# CITY OF ALBUQUERQUE

**Alice King Charter School**  
**Request Permanent C.O. - Accepted**  
**Engineer's Stamp dated: 8-5-16 (J19D085)**  
**Certification dated: 10-25-16**

**RE: Alice King Charter School  
Grading and Drainage Plan  
Engineer's Stamp Date 4-19-2016 (File: J19D085)  
Updated Plan Stamp Date 8-3-2016**

**RE: Alice King Charter School  
Grading and Drainage Plan  
Engineer's Stamp Date 4-19-2016 (File: J19D085)**

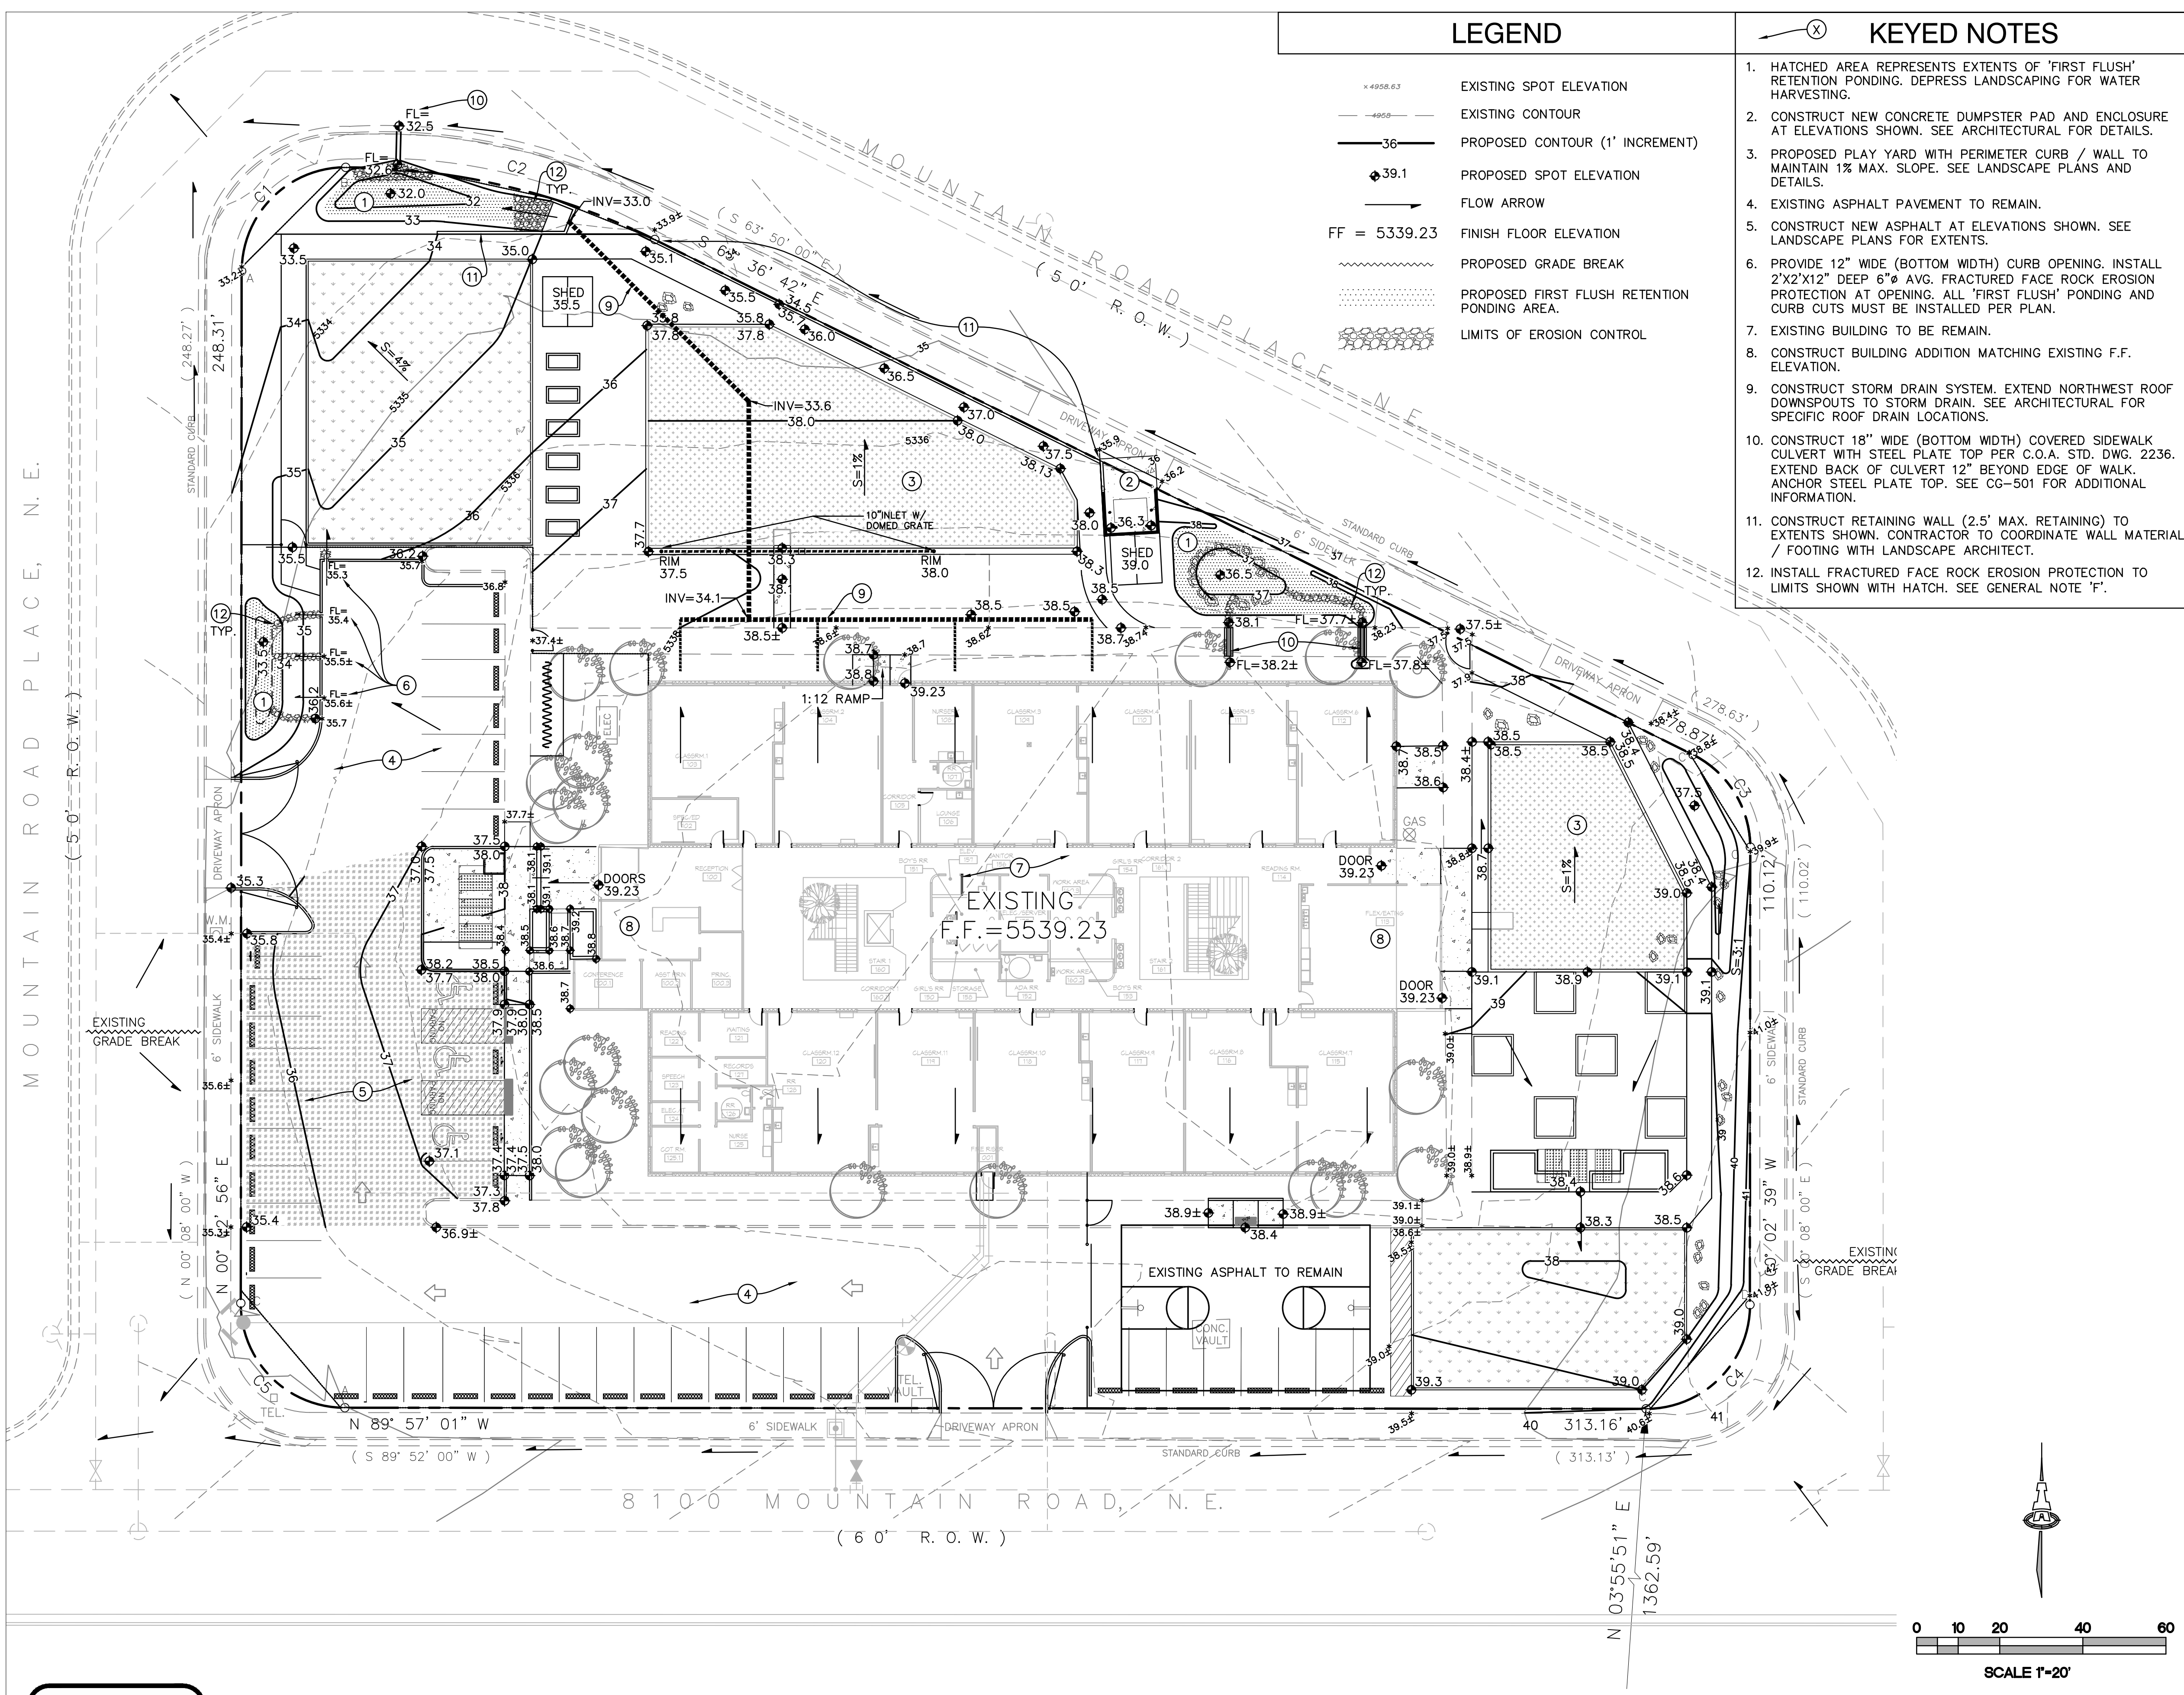
1. Coordinate the possible need for a TCL and a NIA with Transportation Development.
2. Ensure that the new dumpster enclosure area is connected to an SAS if possible.
3. The site generally drains to the Northwest, so an overflow sidewalk culvert spillway would be needed for the north westernmost first flush pond (through SO-19 Permit).
4. The Drainage Plan needs to include a comparison of existing vs proposed hydrologic conditions.
5. Please stamp and date the 'Final' plan.

DRAWING SHEET
TLC 101

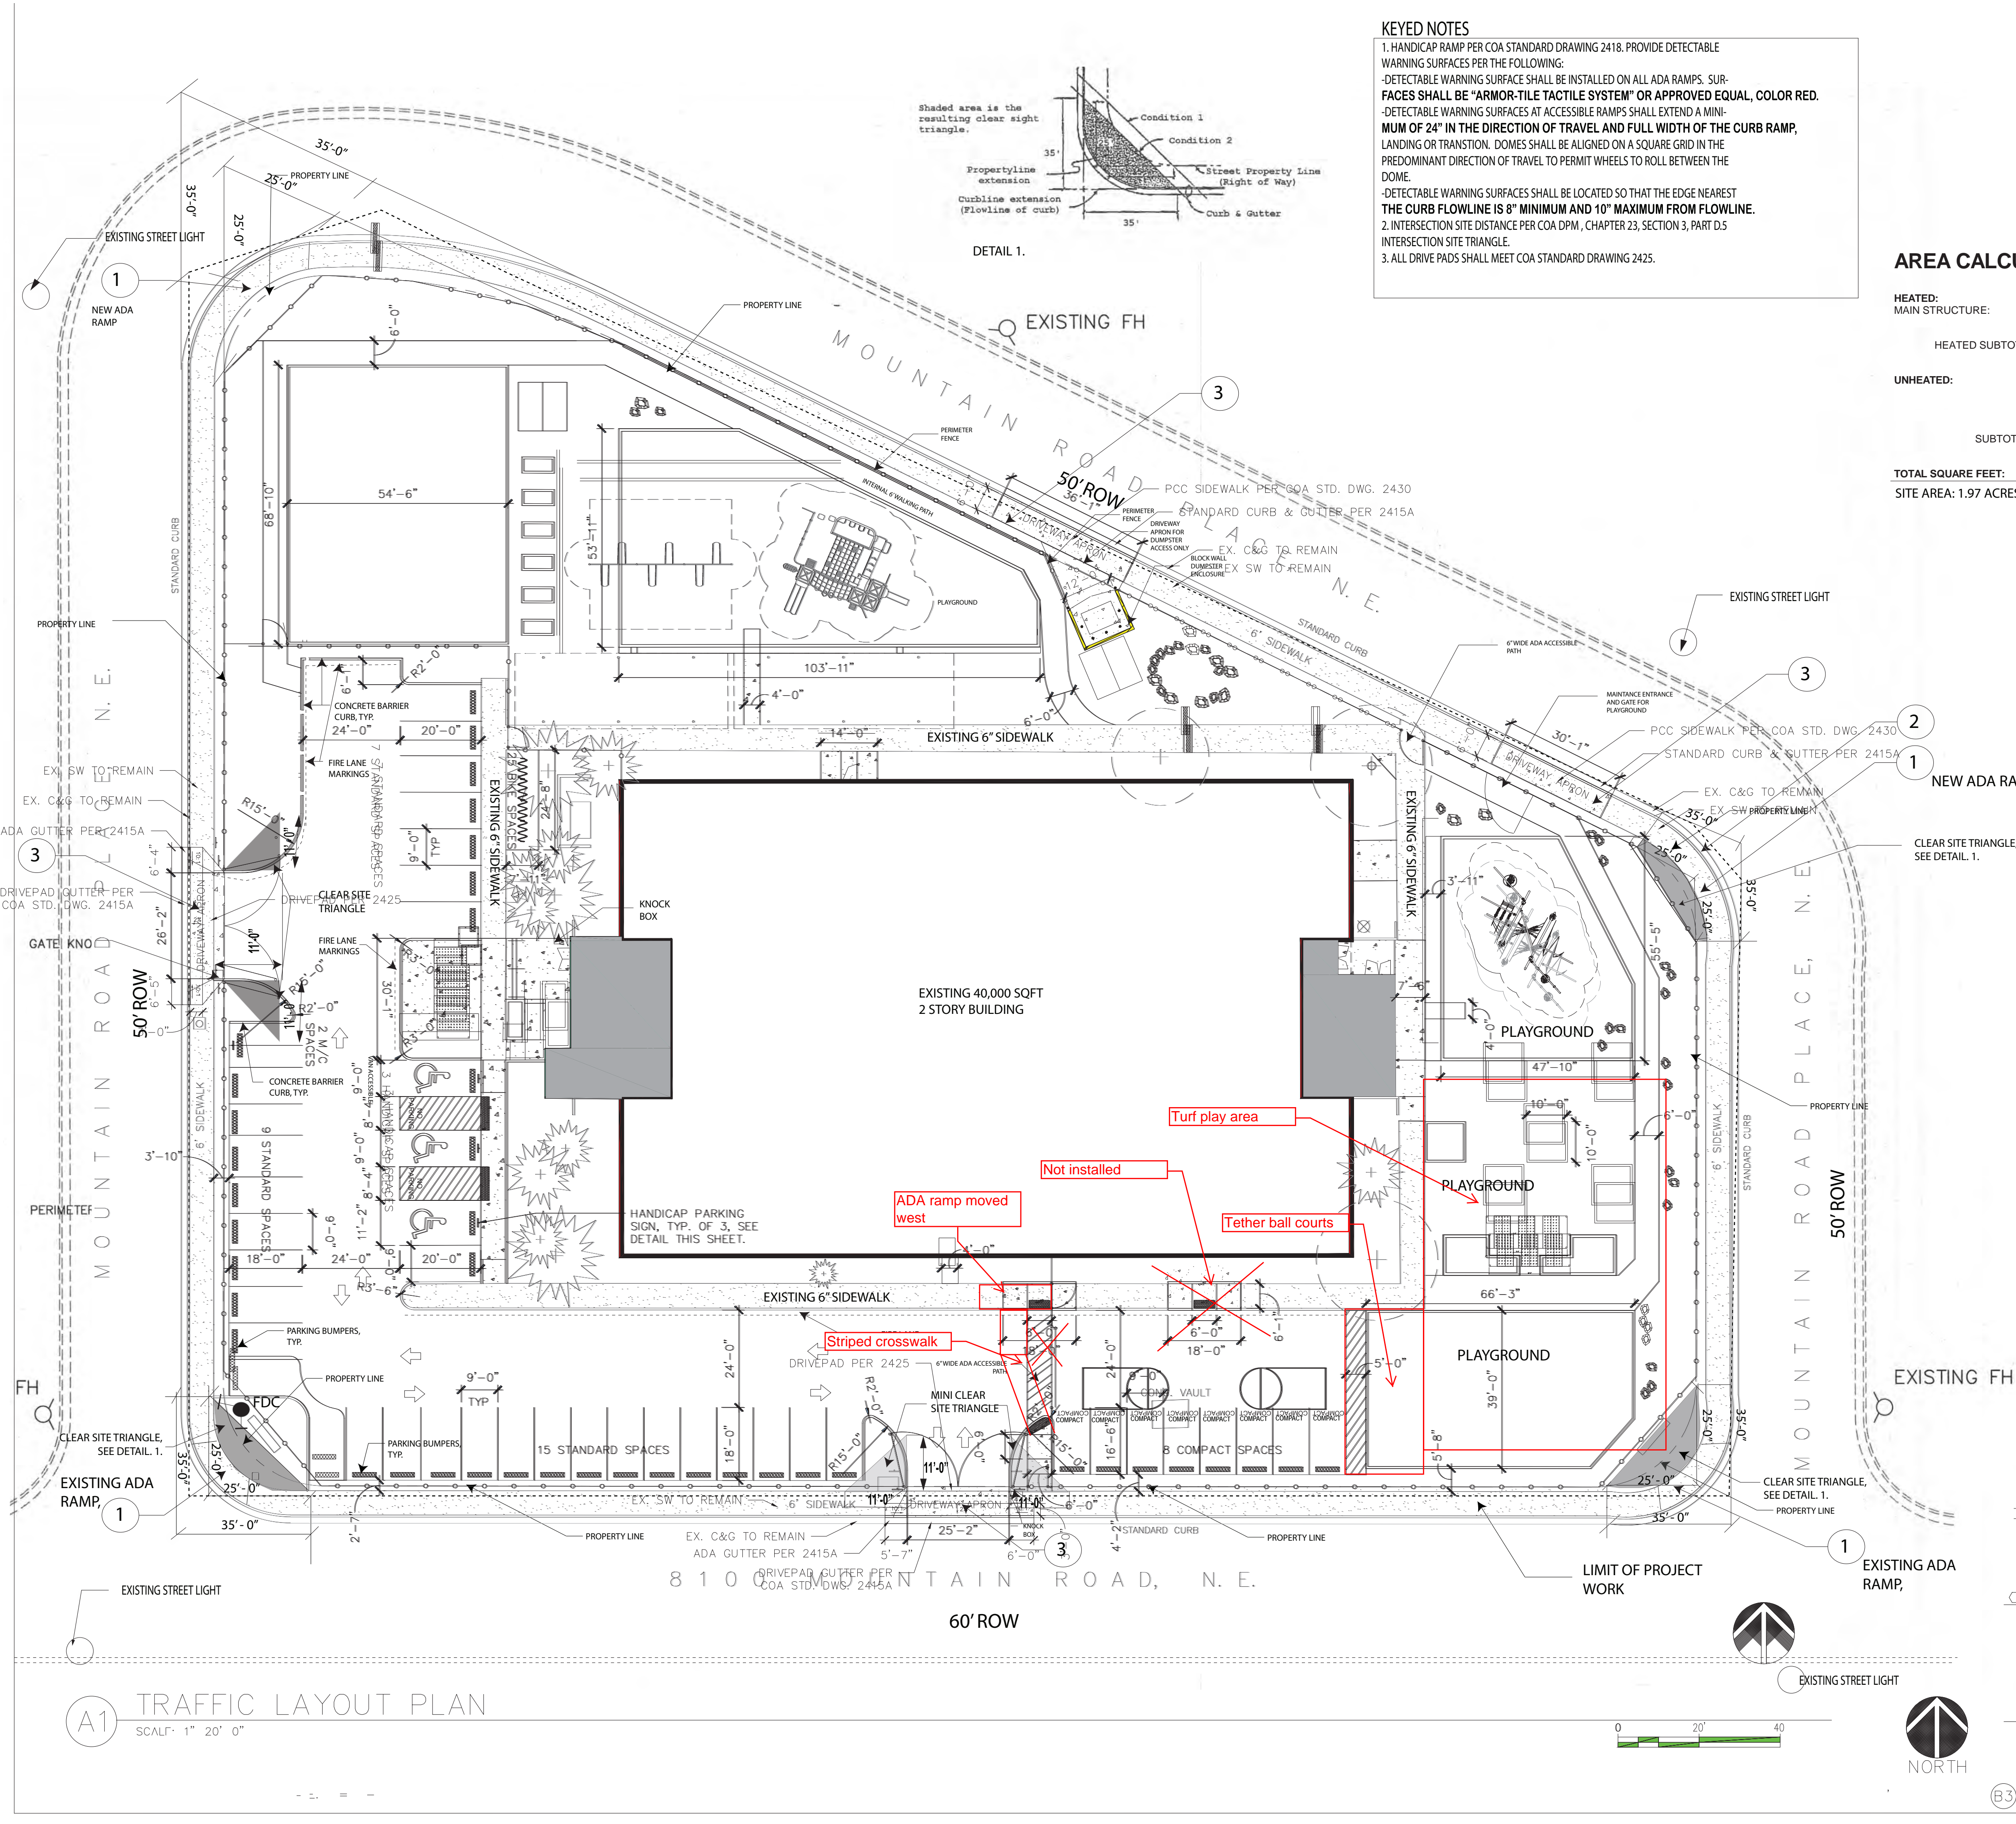
1. Clarify the extents of the current phase. Please detail the proposed additions to the parcel.
2. The traffic circulation layout must be stamped, signed, and dated by an engineer or architect licensed in the state of New Mexico.

4. A scale of 1"=20' is recommended for sites less than 5 acres.
5. Please identify all existing buildings, structures, sidewalks, curbs, ADA ramps, drive pads, walls and anything that influences the parking and circulation on the site.

6. Identify all existing access easements and rights of way width dimensions.
7. Identify the right of way width, medians, curb cuts, and street widths on Mountain Rd. Place and Mountain Rd.

8. The handicap accessible spaces must be a minimum of 8.5 ft. in width.
9. The handicap accessible spaces must include an 8 ft. wide van access aisle; all other aisles should be 5 ft. in width. In review of the submitted drawing, an 8 ft. van access isle is not provided.

10. The ADA accessible parking sign must have the required language per 66-7-352.4C NMSA 1978 **"Violators Are Subject to a Fine and/or Towing."** Please call out detail and location of HC signs. Please show a detail of signage.

11. Show all drive aisle widths and radii.

12. Per DPM, a 6 ft. wide ADA accessible pedestrian pathway is required from the public sidewalk to the building entrances. Please clearly show this pathway and provide details. In review of the submitted drawing, the ADA pathway cannot be accessed from the drive pad on the north side of the property off of Mountain Road Plc. This drive pad is also used for refuse pick up, posing a possible safety hazard.

13. Provide a min 6" or max 8" high concrete barrier curb or other acceptable barrier between landscaping and parking areas and/or drive aisles. Please call out detail and location of barrier curb.

14. Design delivery vehicle route needs to be shown.
15. Service vehicle and/or refuse vehicle maneuvering must be contained on-site; provide a copy of refuse approval. In review of the submitted drawing, the refuse vehicle should not have to back up into the street after pick up. Please relocate refuse container.

16. It appears that the drive pad at the north east corner of the parcel is no longer required, since there is to be structure placed in that corner. If this is the case, please remove drive pad and replace with standard curb and gutter per COA standards.

17. Please provide a sight distance exhibit (see the *Development Process Manual, Chapter 23, Section 3, Part D.5 Intersection Sight Distance*). Please call out this detail at the north east corner of the project site, if the drive pad is to be utilized.
